**Consultation Response from KC,
Highways Development Management**

2024/90664 Unit C9a Ground Floor, Carlinghow Mills, 501, Bradford Road, Batley, WF17 8LN

Change of use from offices to nursery, erection of front porch, formation of parking area and associated external alterations (within a Conservation Area).

**Proposed Site Plan**  
1 : 200

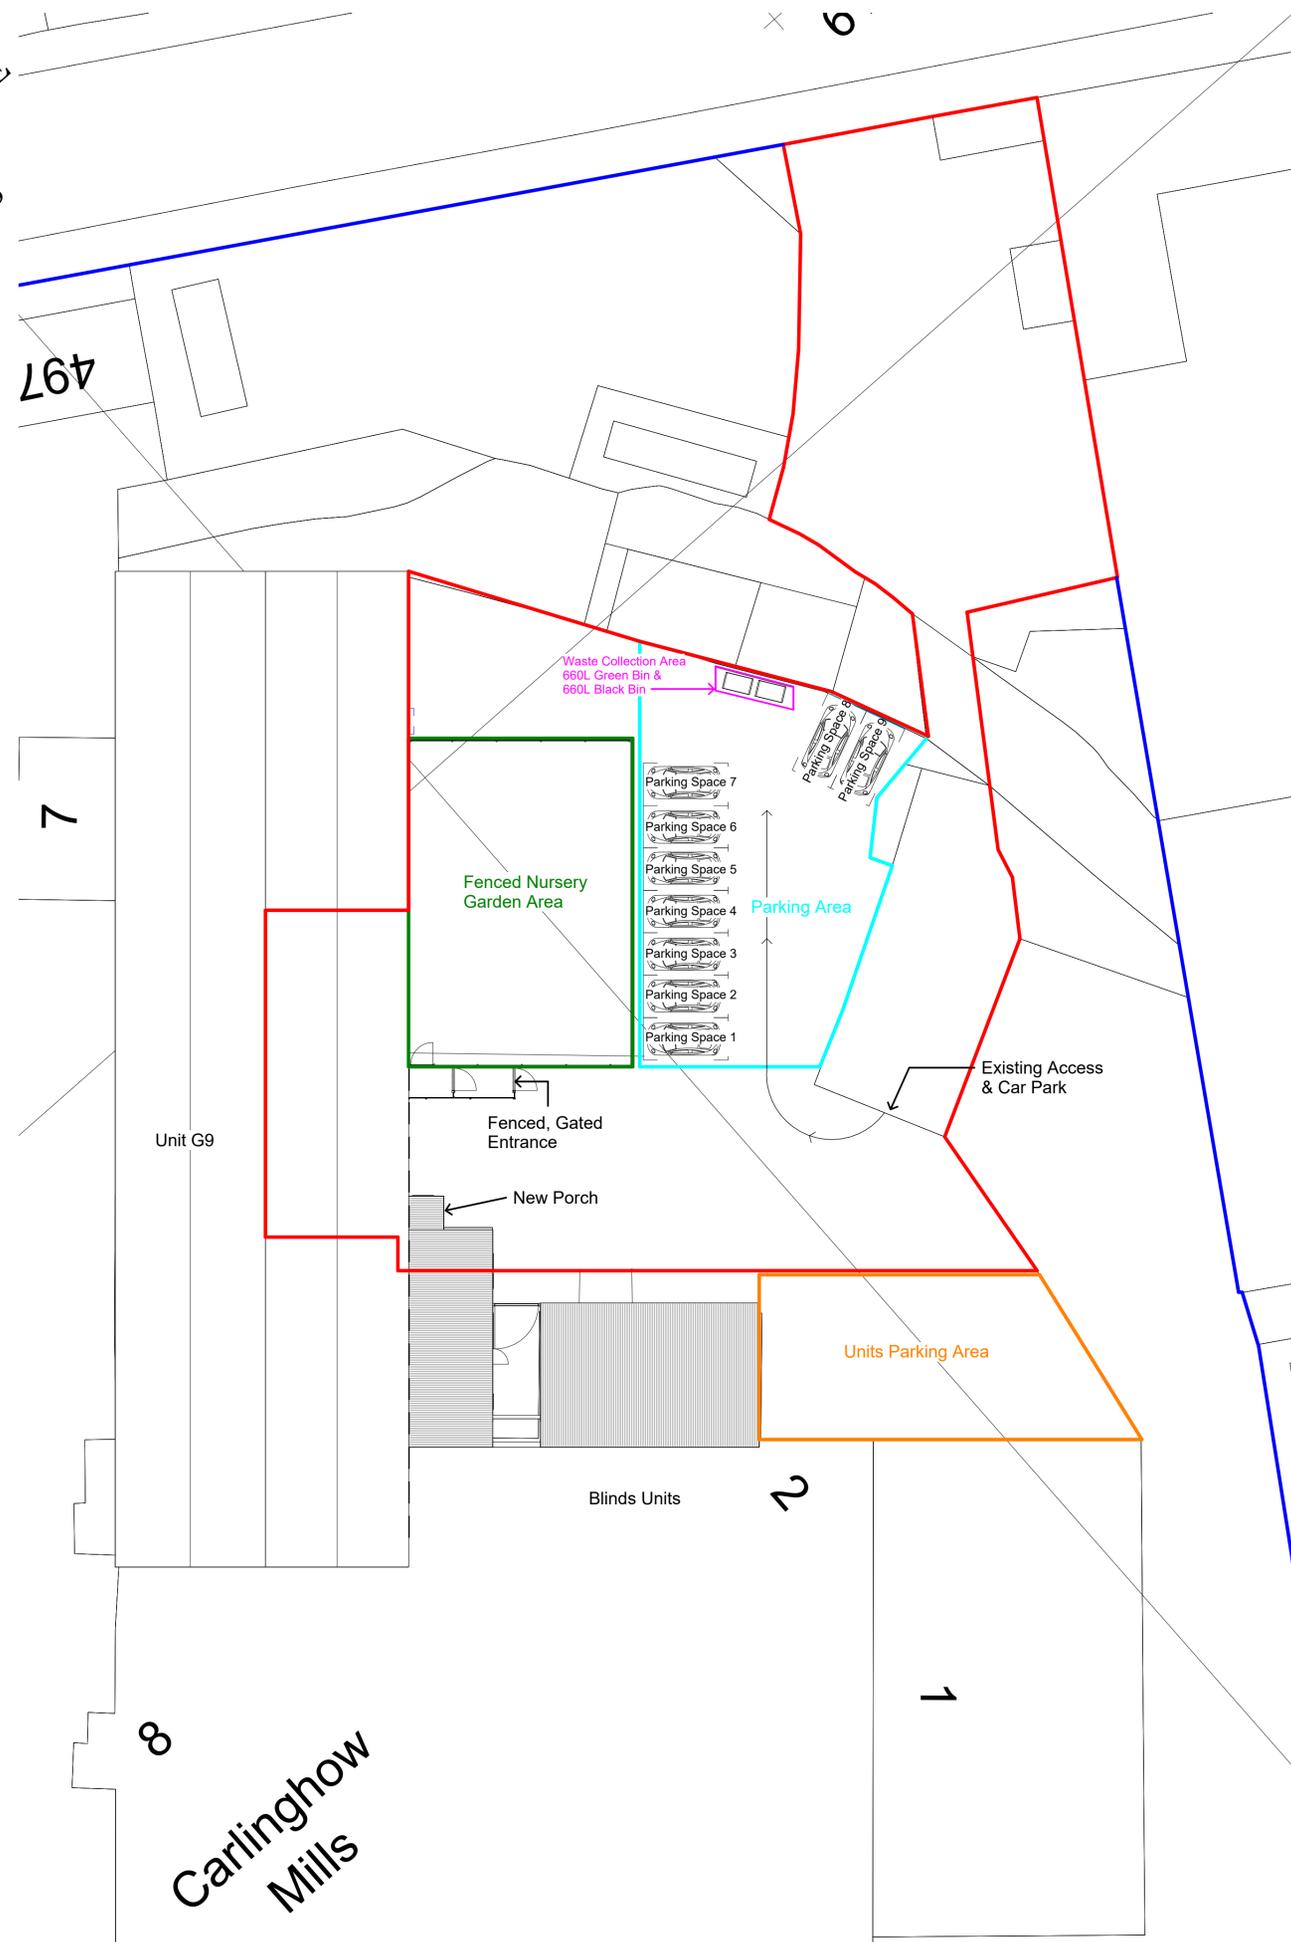
Whilst Highways Development Management have concerns regarding the lack of a pedestrian access into the site given the location it is considered that most children will be taken to the nursery by car. Given that ample off-street parking is shown to be provided for staff and for the drop off and pick up of children on-balance this application is therefore acceptable.

Prior to the development being brought into use, the proposed car parking areas hereby approved shall be laid out surfaced, marked out into bays and drained in accordance with details that have previously been approved in writing by the Local Planning Authority.
